MONA OFFSHORE WIND PROJECT

Response to Martyn and Margaret Hussey ExQ1 Responses

Application Reference: EN010137

Document Reference: S_D4_39

ONSHORE SUBSTATION CROSS SECTION 1
SCALE: H 1:500, V 1:500. DATUM: 50.000

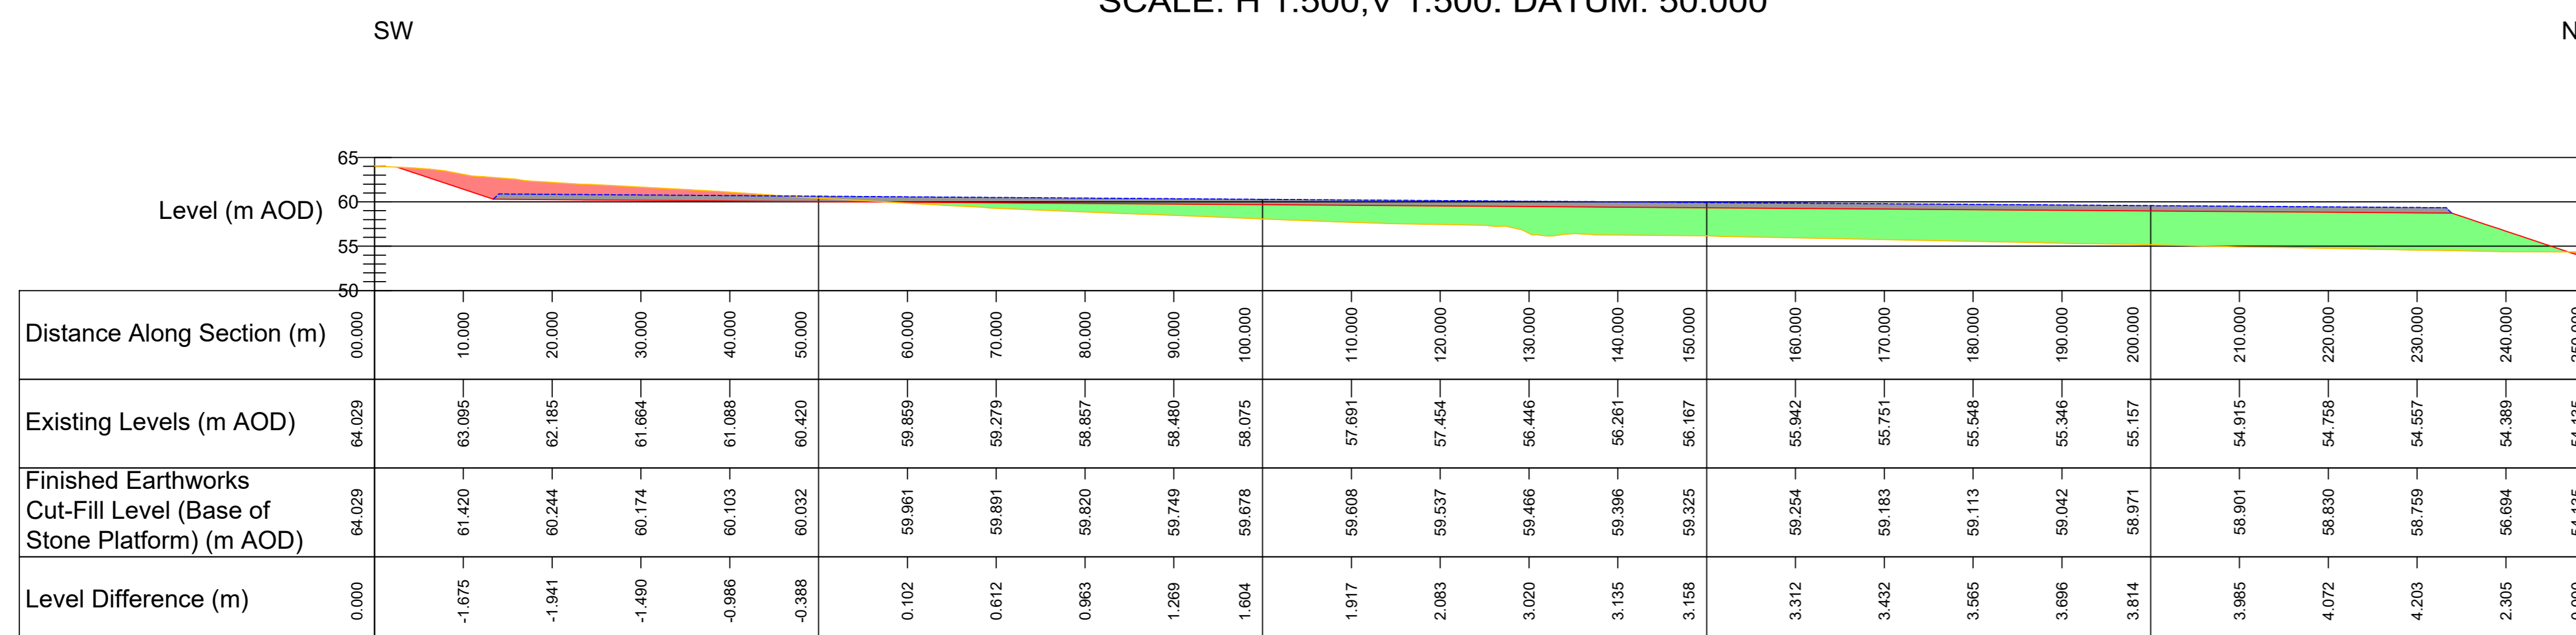
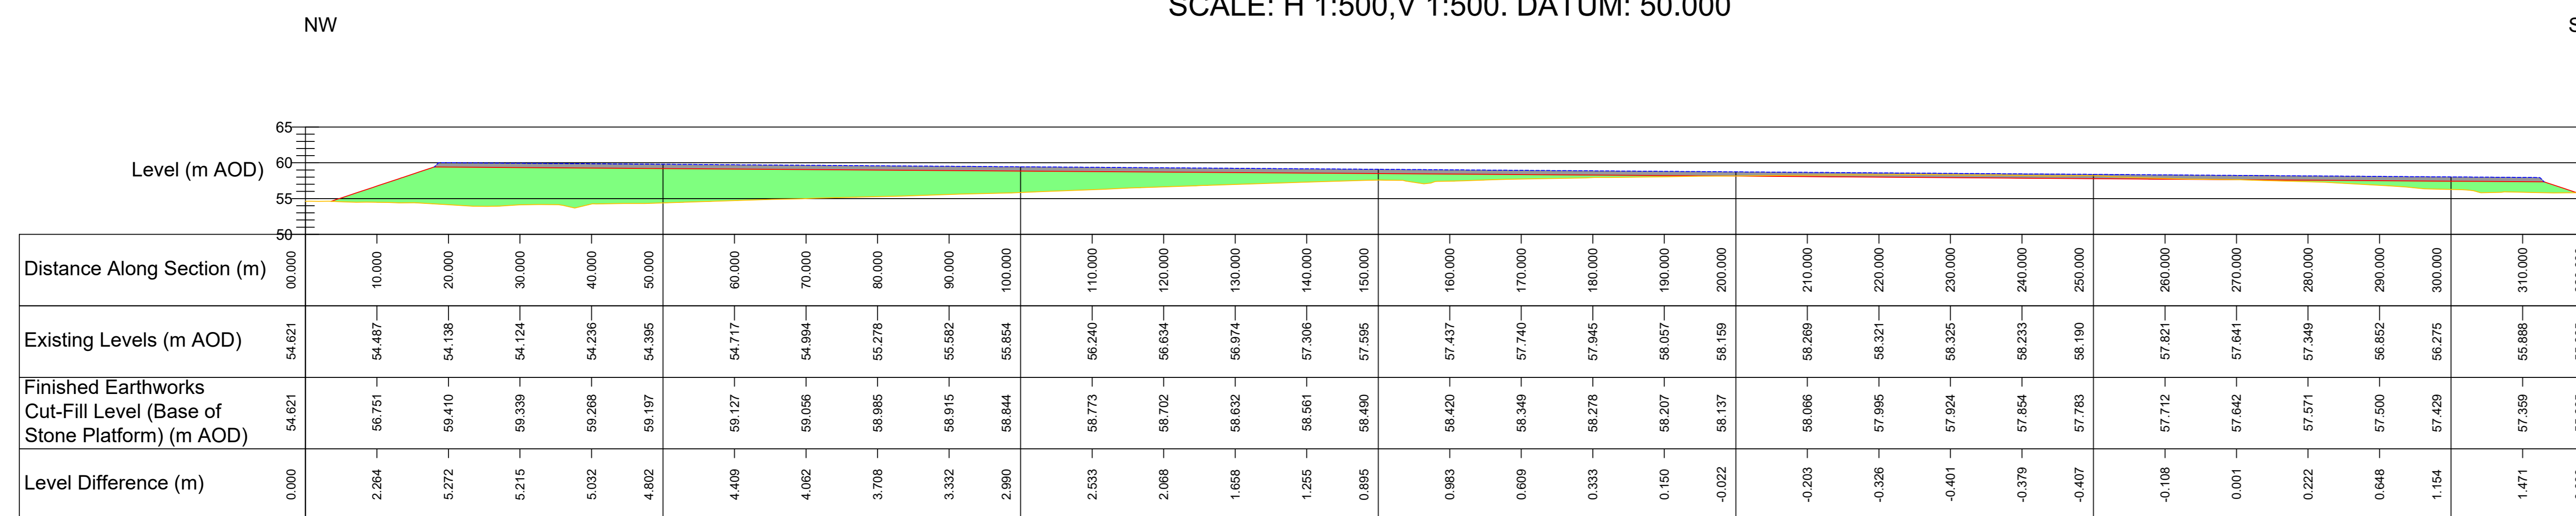
Planning Inspectorate Ref. No.	Question is addressed to	ExA Question	Martyn and Margaret Hussey response	Applicant's response
				<p>(document ref J26.3 F03) that requires confirmation of construction vibration levels to be identified once detailed design has been undertaken. These predictions will be presented in the Final Construction Noise and Vibration Management Plan for approval by the relevant planning authority This would also include any necessary mitigation to ensure levels are compliant with the relevant vibration standards. Should the planning authority not agree with the proposals, the Applicant would provide alternative construction methods where necessary..</p> <p>The Applicant has offered a meeting with the residents of Tyddyn Meredydd to answer any questions arising from the information provided by the Applicant at Deadline 4.</p>
